Subject: Inglenook Development

Inglenook Hotel Development Application for 9 dwellings

The Transport Statement provided by RGP (only two paragraphs) does not address fully the safety of vulnerable road users who will feel threatened by having no space protected from vehicles, particularly wheelchair and partially sighted users and children who will certainly be using the access to get to school and to the bus stop.

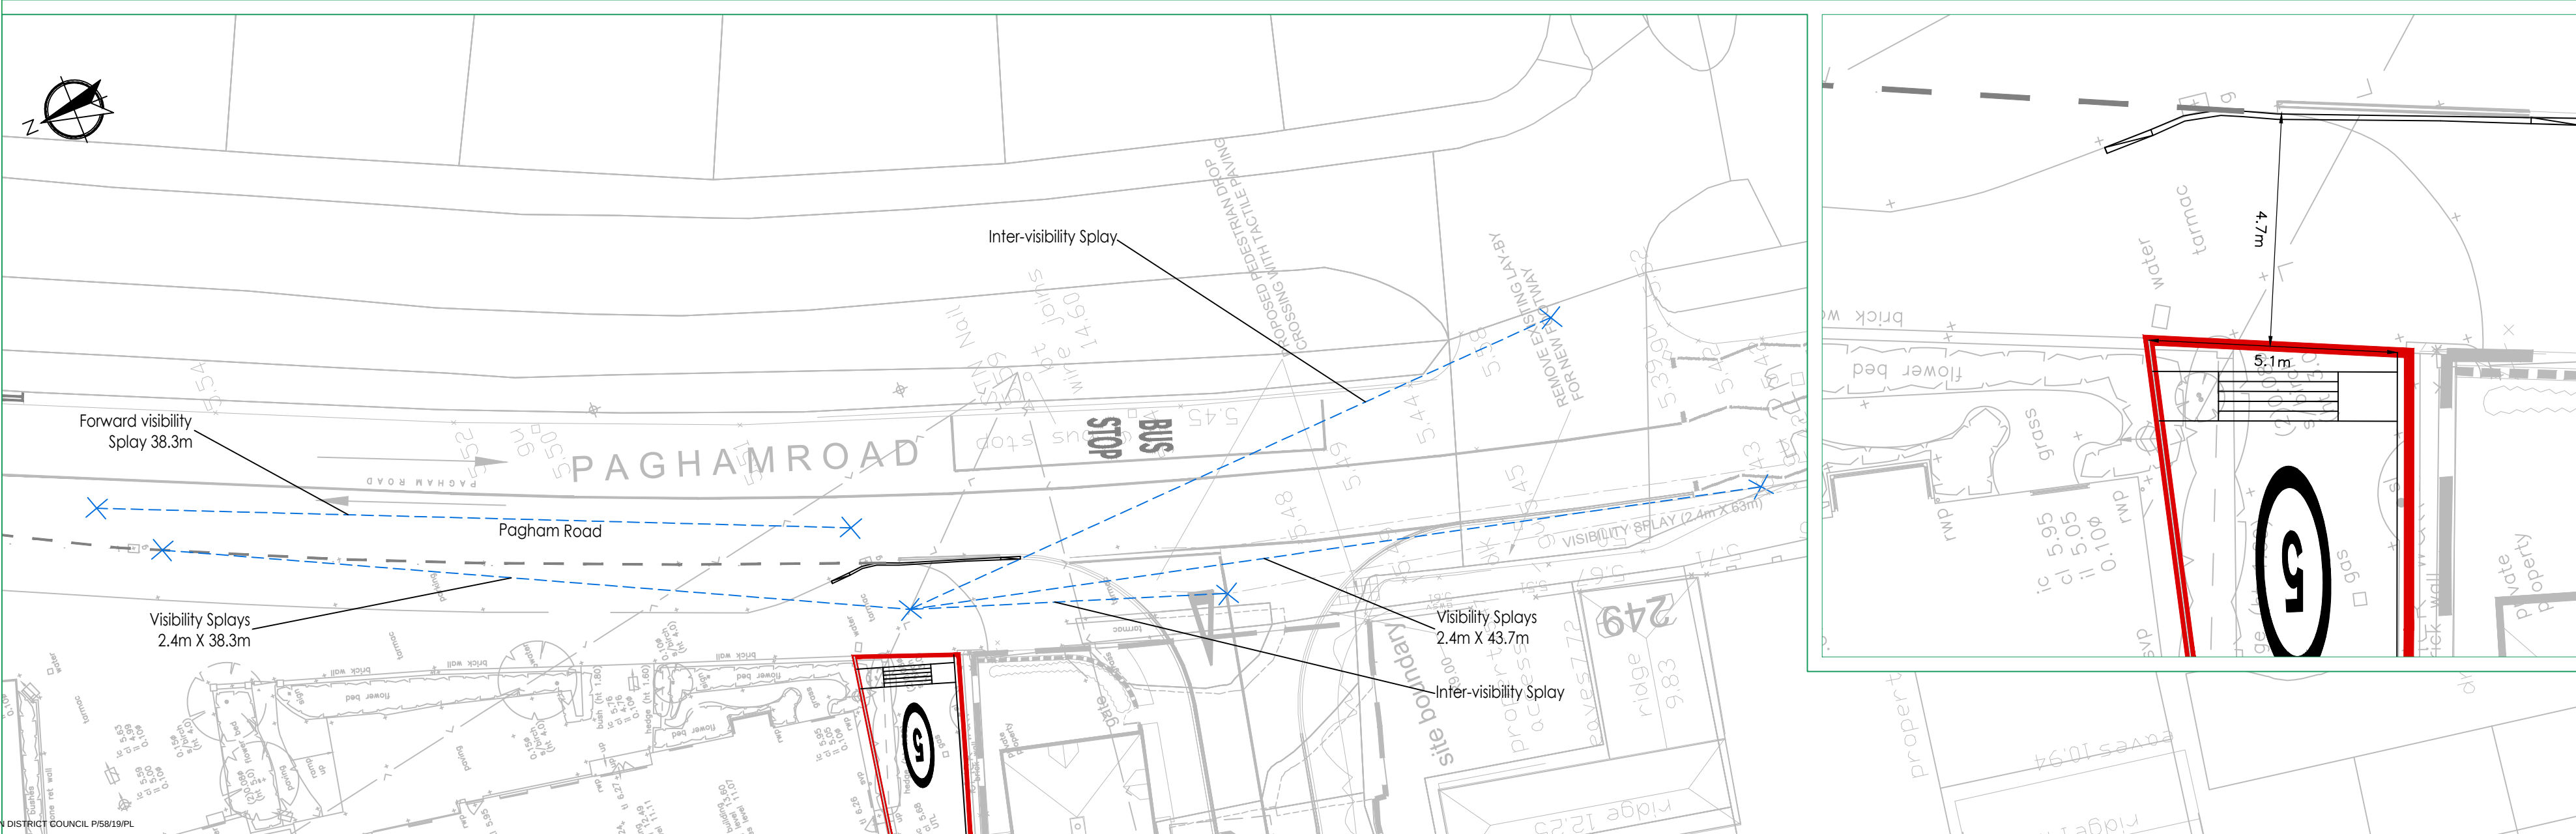
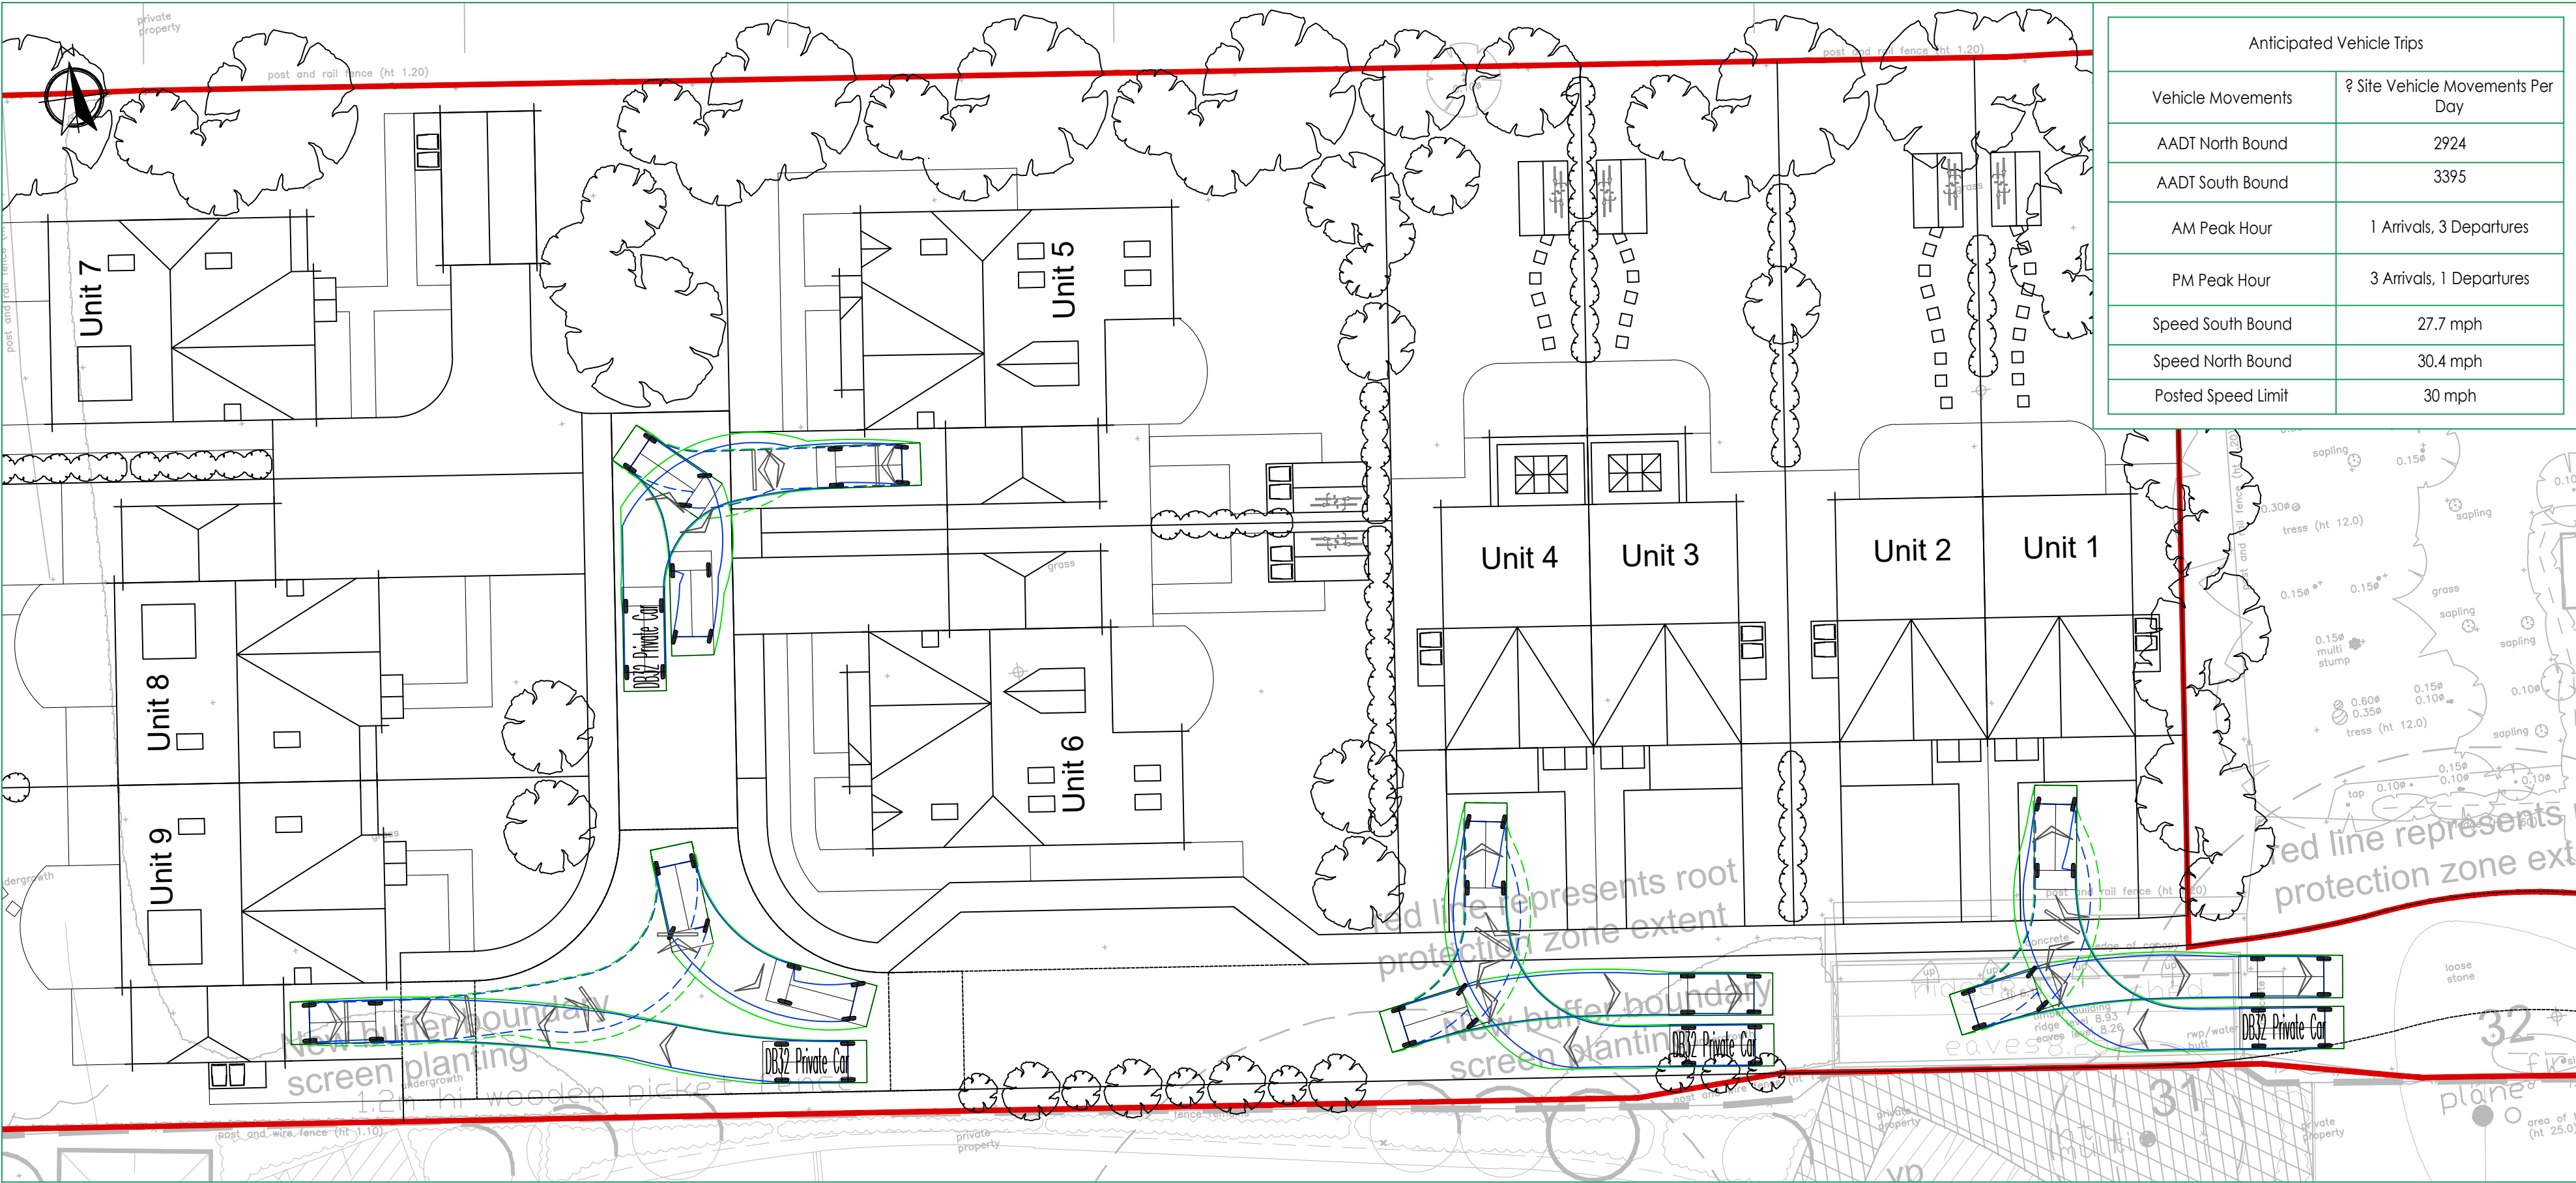
Mr Crowther's comments that the existing access 'is not ideal' and that 'if this were a new junction and access it would not be passed' is mystifying. It was a new access and junction at some point and presumably Highways were consulted originally. What happened? Does he really believe that exacerbating an already 'not ideal' situation by placing pedestrians in the lane and adding a further 46-48 vehicle movements is the right way forward.
